From: Laura Gibbons
Sent: 20 April 2018 11:29
To: Planning.Responses
Subject: RE: Planning Consultation on: AL/37/18/HH

Engineers comments in respect to surface water drainage:
Please apply standard condition ENGD2A.

APPLICATION **AL/37/18/HH**

Description of Works: Orangery to rear elevation. This application affects the character & appearance of the Norton Lane, Norton Conservation Area.

PROPOSED ORANGERY

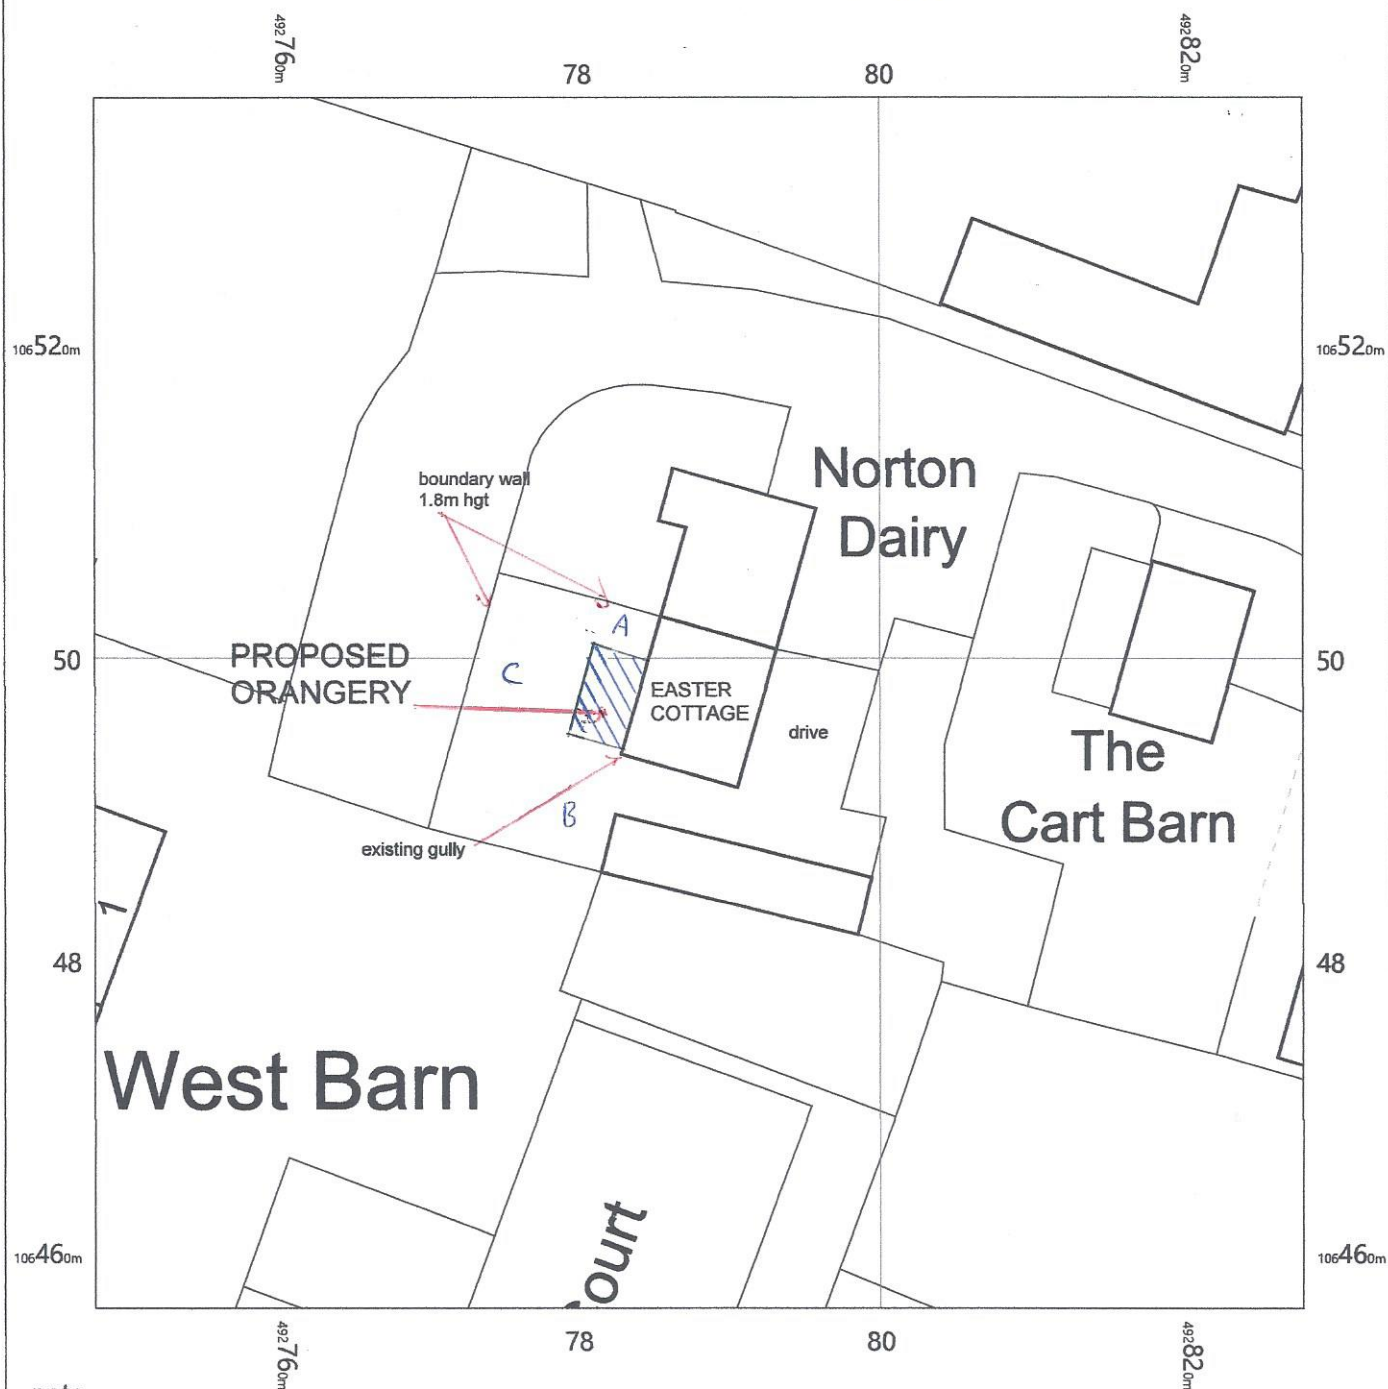
Soakaways must be investigated for surface water disposal.

Infiltration rates for soakage structures are to be based on percolation tests undertaken in the winter period and at the location and depth of the proposed structures. The percolation tests must be carried out in accordance with BRE 365, CIRIA R156 or a similar approved method and cater for the 1 in 10 year storm between the invert of the entry pipe to the soakaway, and the base of the structure. It must also have provision to ensure that there is capacity in the system to contain below ground level the 1 in 100 year event plus 40% on stored volumes, as an allowance for climate change. Adequate freeboard must be provided between the base of the soakaway structure and the highest recorded annual groundwater level identified in that location.

Any SuDS or soakaway design must include adequate groundwater monitoring data to determine the highest winter groundwater table in support of the design. The applicant is advised to discuss the extent of groundwater monitoring with the Council's Engineers. Supplementary guidance notes are also enclosed for information.
